**From:** Mundy, Ben - Oxfordshire County Council <Ben.Mundy@Oxfordshire.gov.uk>  
**Sent:** 21 February 2023 09:42  
**To:** Jake Collinge  
**Cc:** Rebekah Morgan  
**Subject:** RE: 22/03049/OUT: Land West of Oxford Close and North of Corner Farm, Kirtlington

**From:** Jake Collinge <jake@jcpc.org.uk>  
**Sent:** 17 February 2023 16:33  
**To:** Mundy, Ben - Oxfordshire County Council <Ben.Mundy@Oxfordshire.gov.uk>  
**Cc:** Rebekah Morgan <rebekah.morgan@cherwell-dc.gov.uk>; Daniel Moore <Dan@manorwoodhomes.co.uk>  
**Subject:** 22/03049/OUT: Land West of Oxford Close and North of Corner Farm, Kirtlington  
**Importance:** High

Drawing No:  
**1001.102**

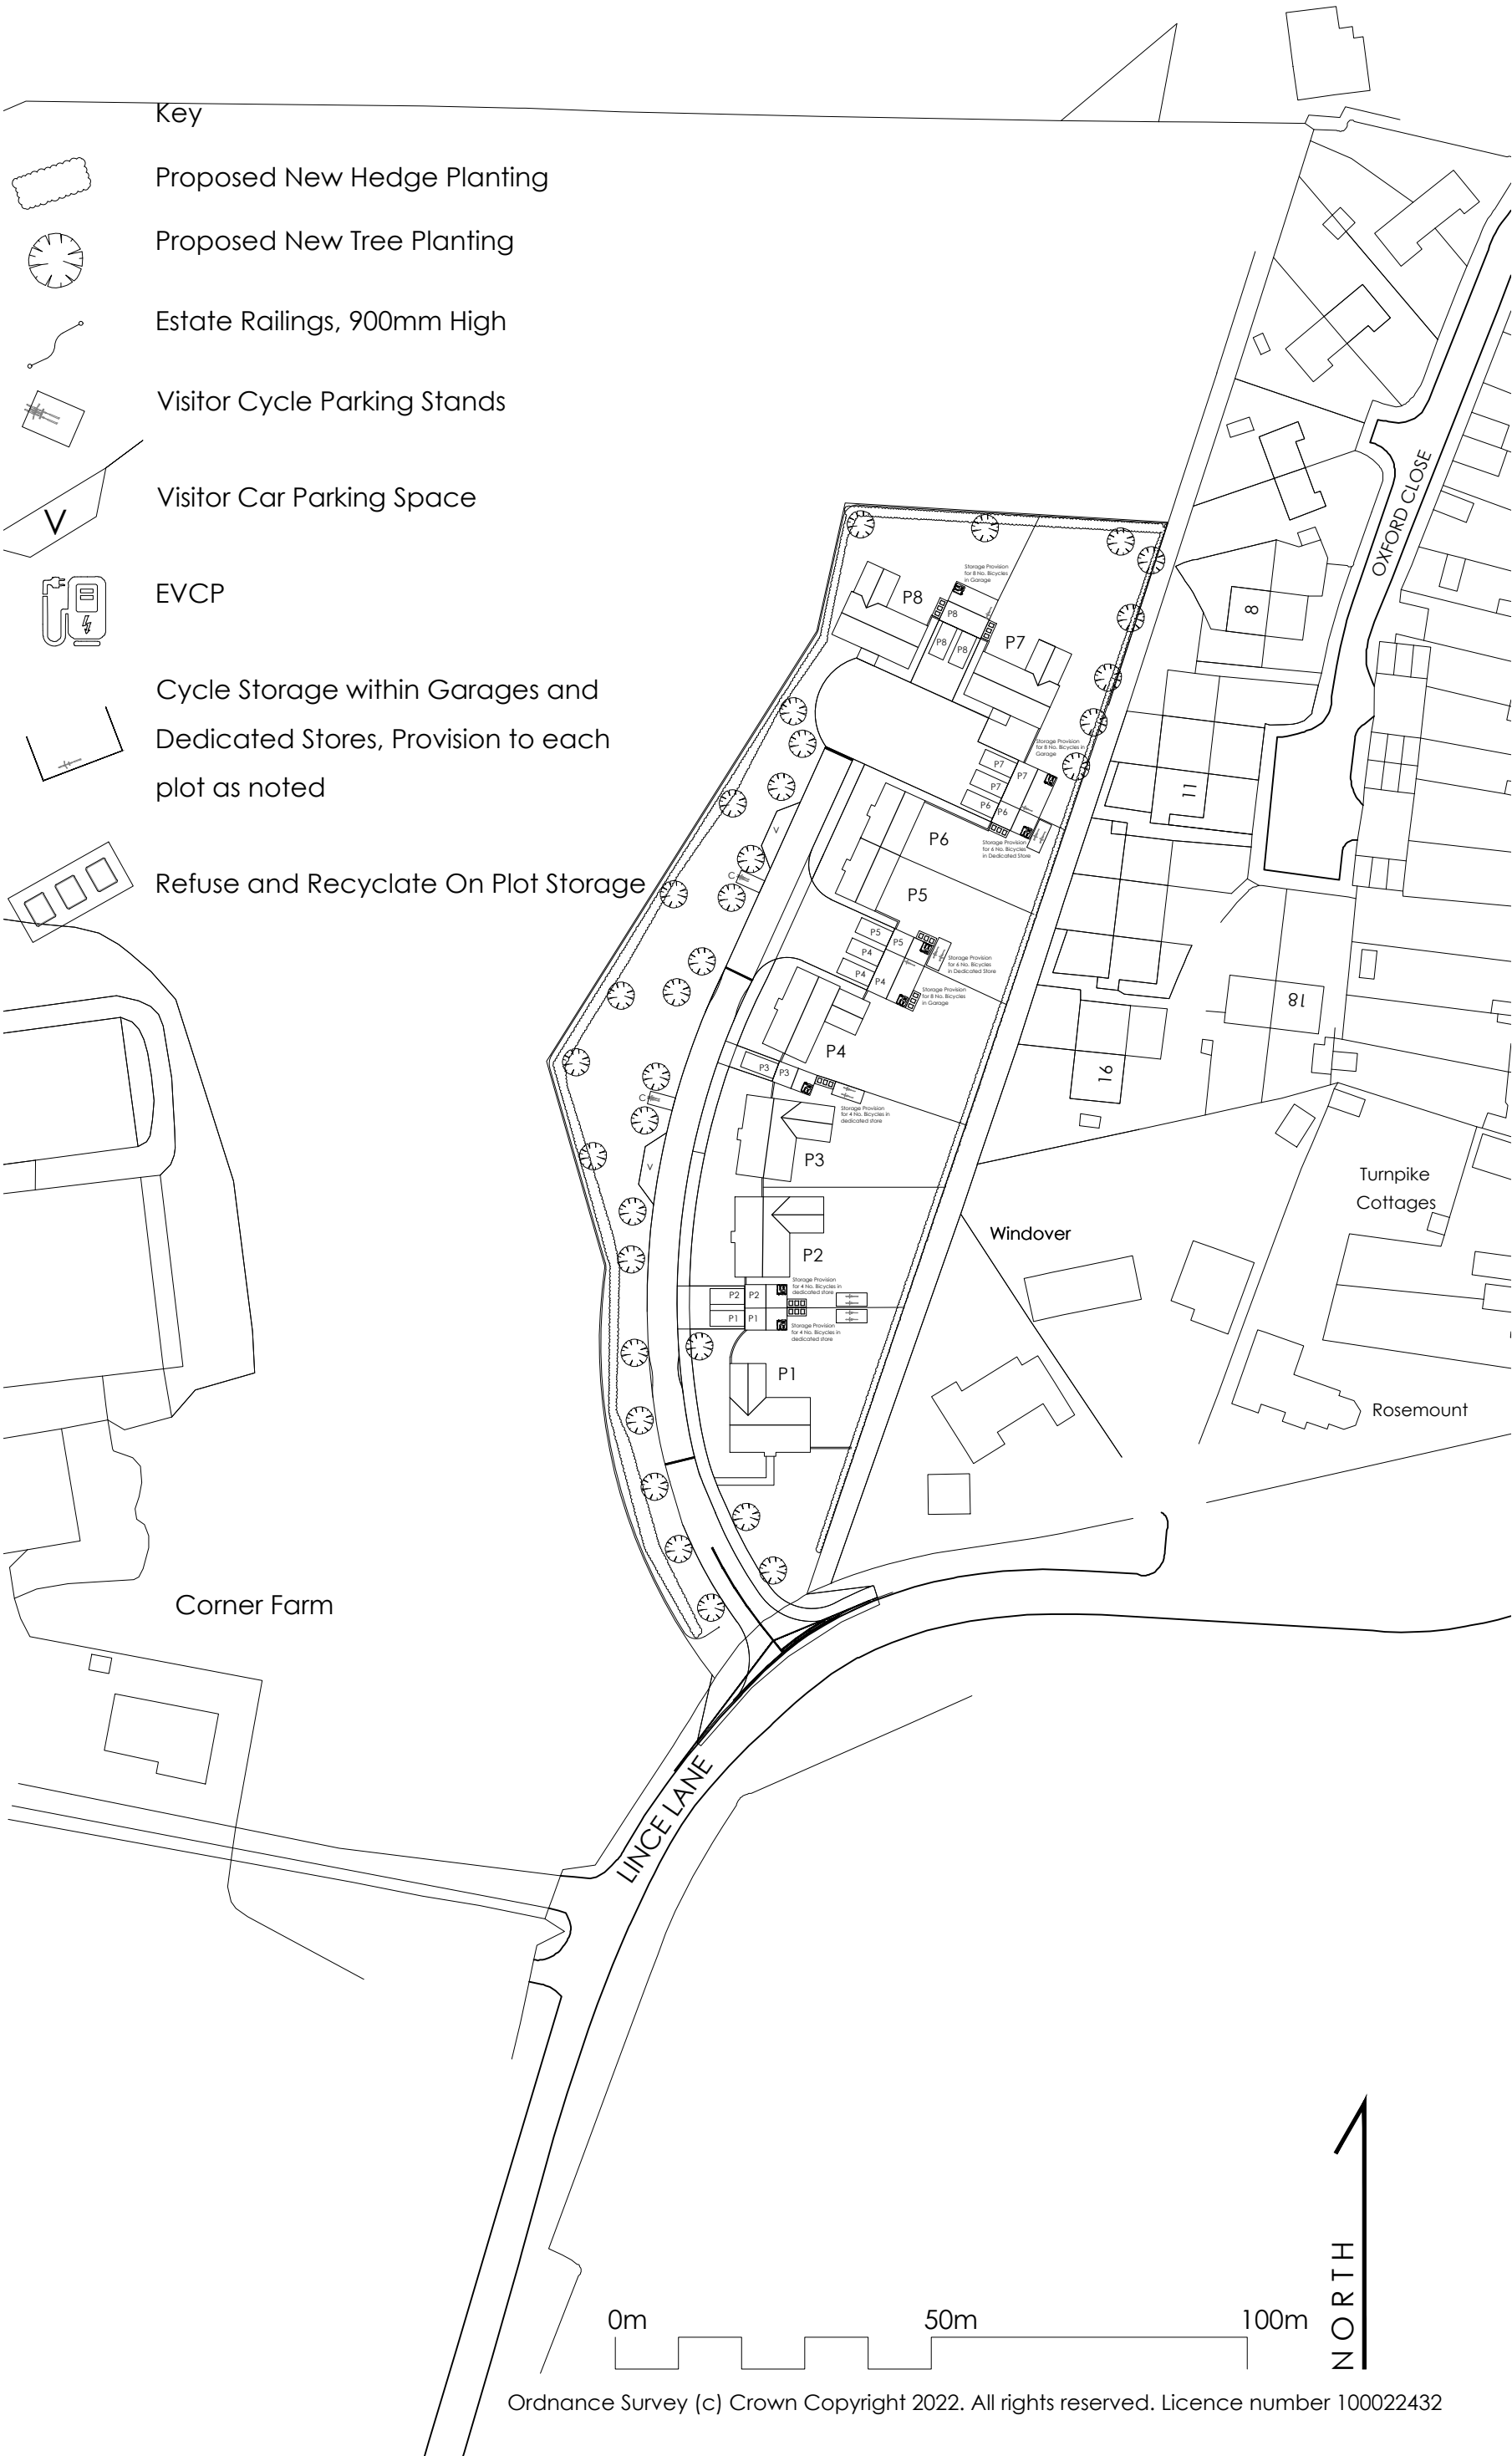
- Cycle Parking is now up to standard
- Speed surveys are acceptable and the visibility demonstrated conforms to guidance within MFS.
- Parking allocation now conforms to standards.
